CHANGE SCHEDULE

REV B - 17.06.26

Figure 2.0 – Proposed Lower Ground Floor Plan (MHNDU)

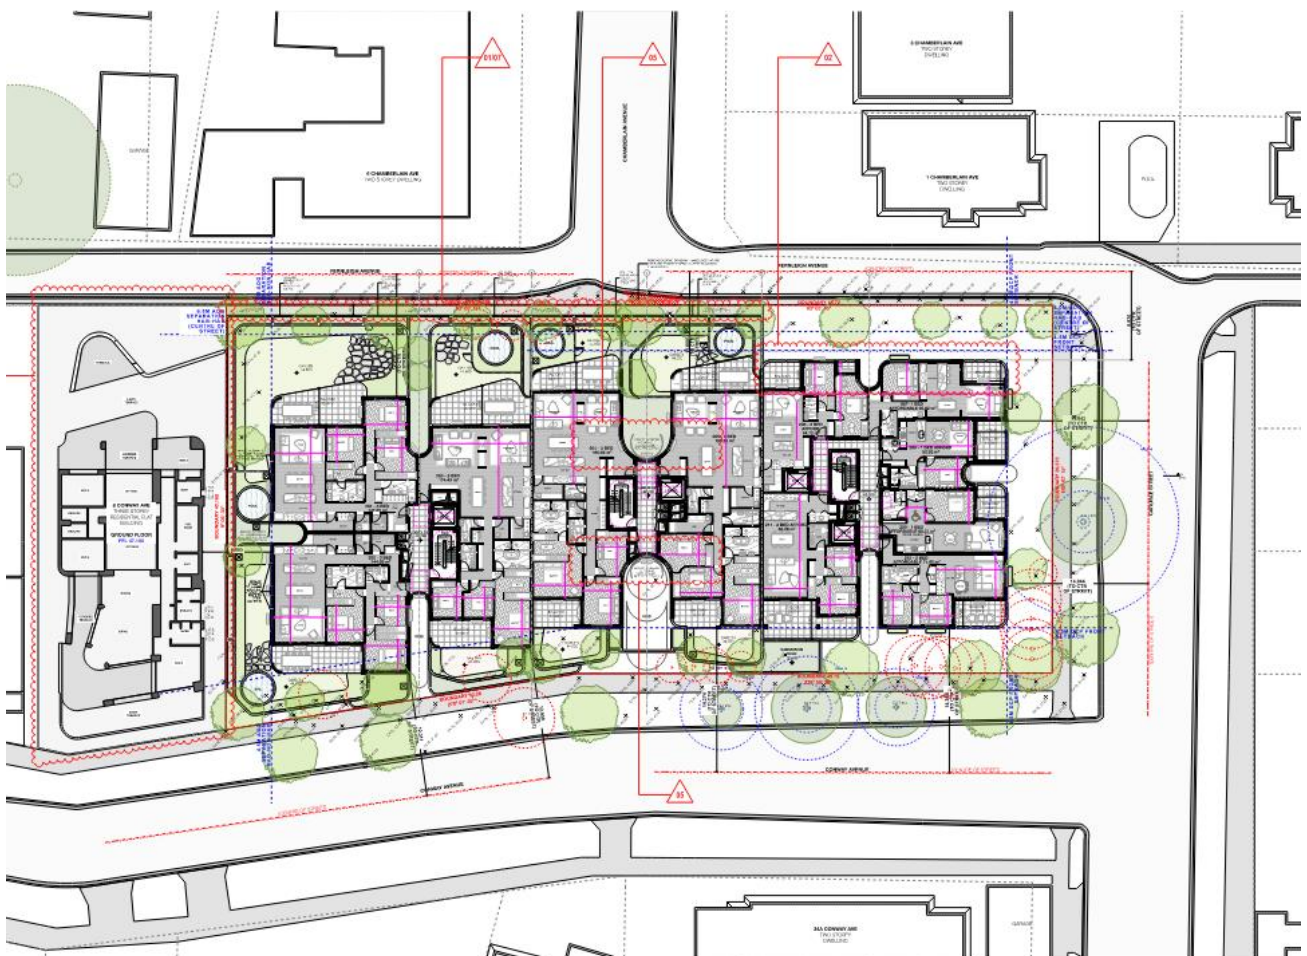
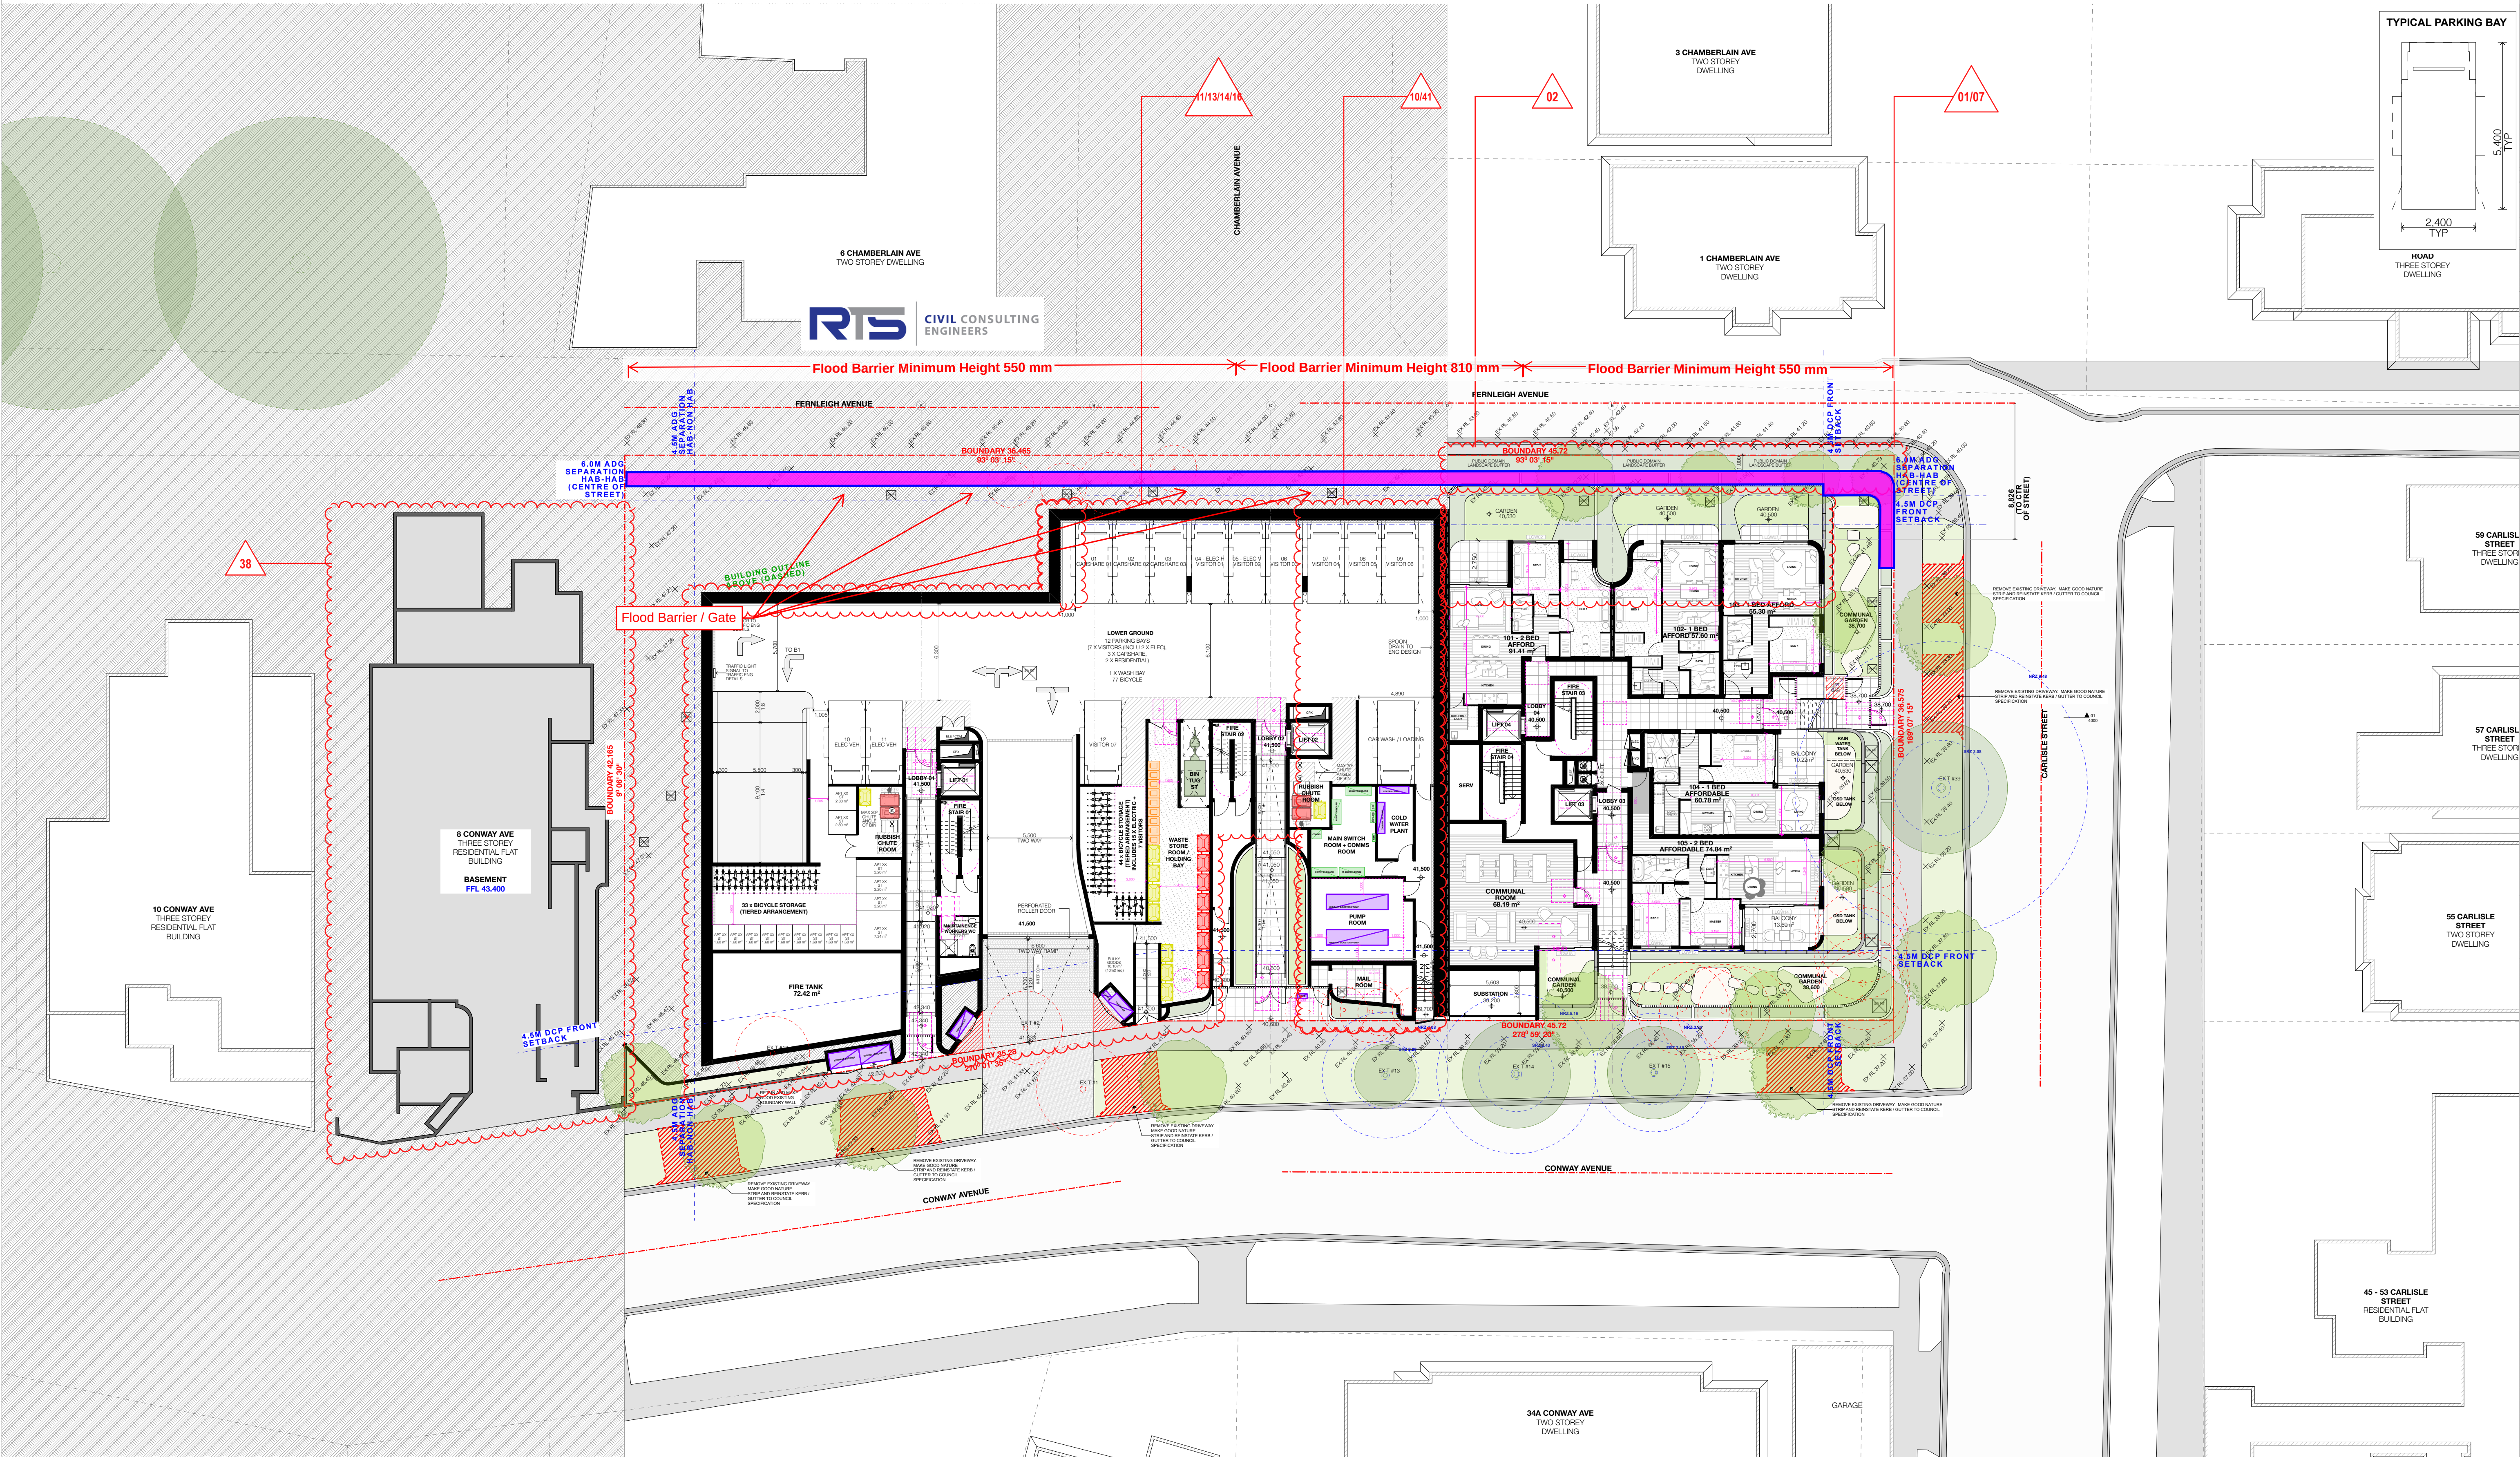
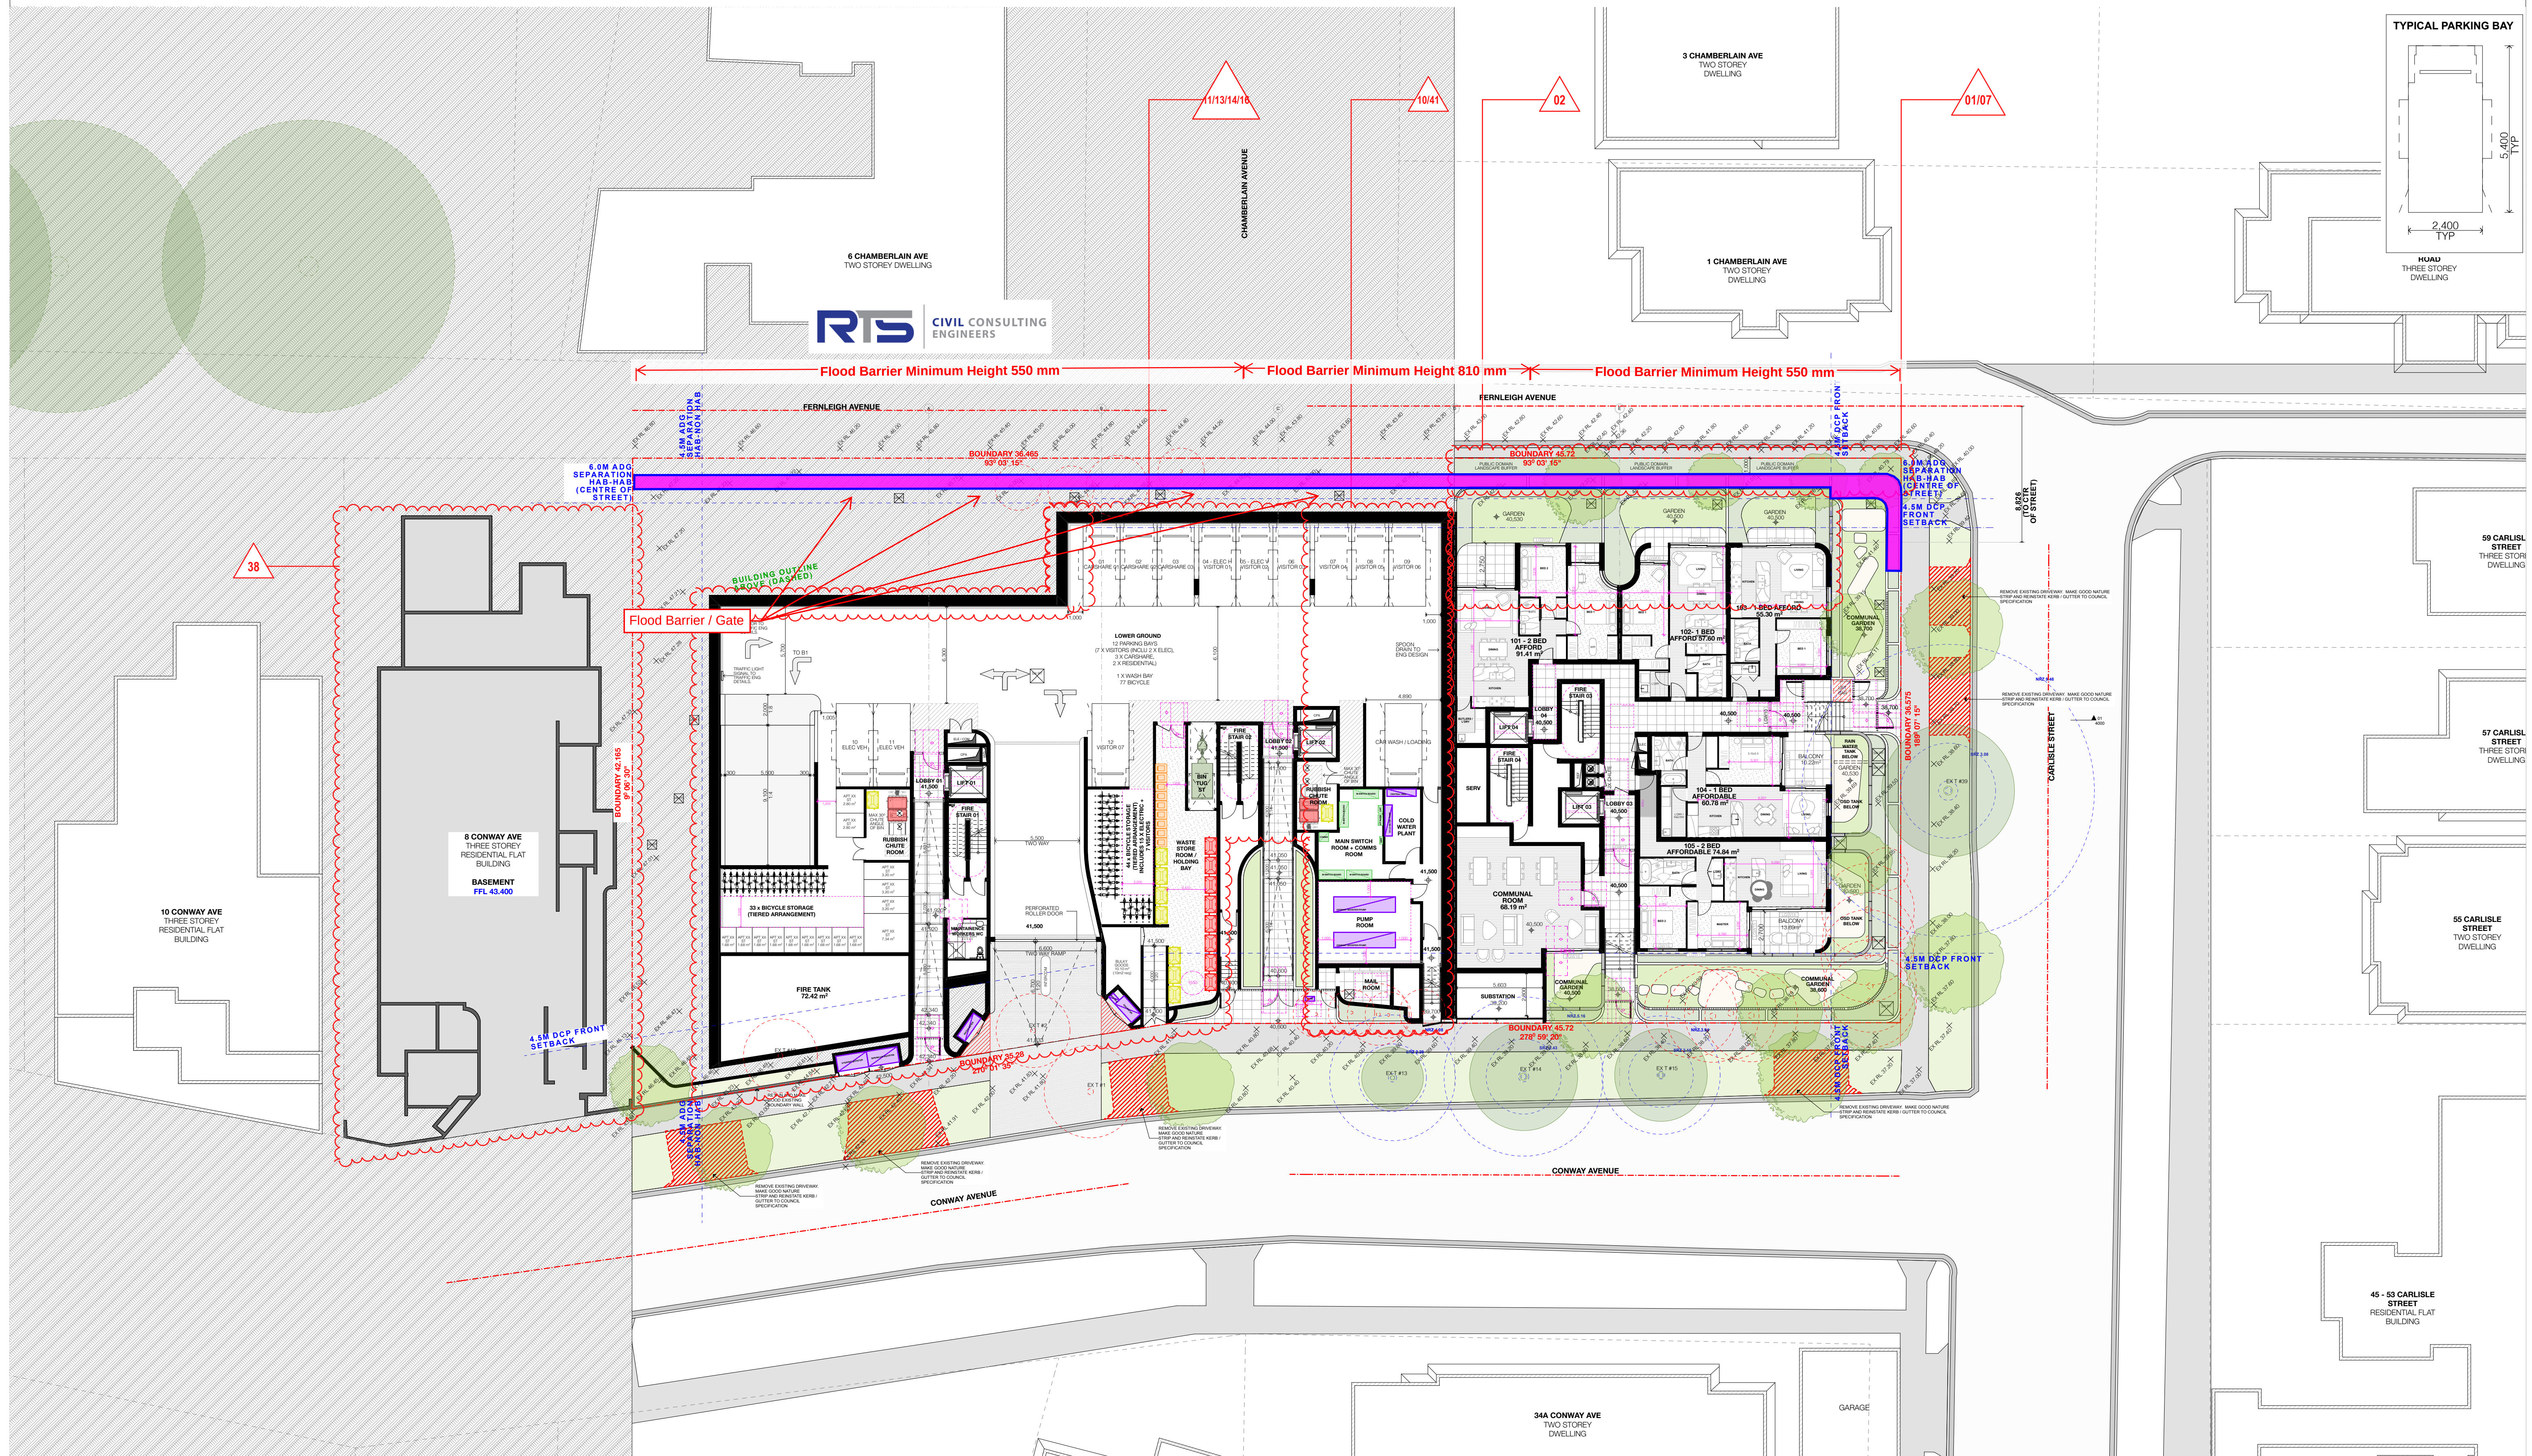
BASEMENT DESIGN AND CAR PARKING		
DPHI ITEM 11

Revise the design of the basement so it does not encroach outside the building footprint into the side or rear setbacks. This would also allow more deep soil planting in the setbacks to the visual impacts of the proposal from the public domain and adjoining properties.	Basement has been revised with the North-east corner removed such that the basement is generally located within the footprint of the building above. Note outline of building above has been included on basement plans in dashed green. Note as such parking numbers have been reduced and deep soil increased. Basement storage has also be reconfigured due to the amended parking layout.	2100 - Basement 02 (1:200) - Rev B 2101 - Basement 01 (1:200) - Rev B 2102 - Lower Ground Floor Plan (1:200) - Rev B 2201 - Basement 02 (1:100) - Rev B 2202 - Basement 01 (1:100) - Rev B 2202 - Lower Ground Floor Plan (1:100) - Rev B 4001 - Section BB - Rev B 6025 - Basement Setout Plan - Rev B
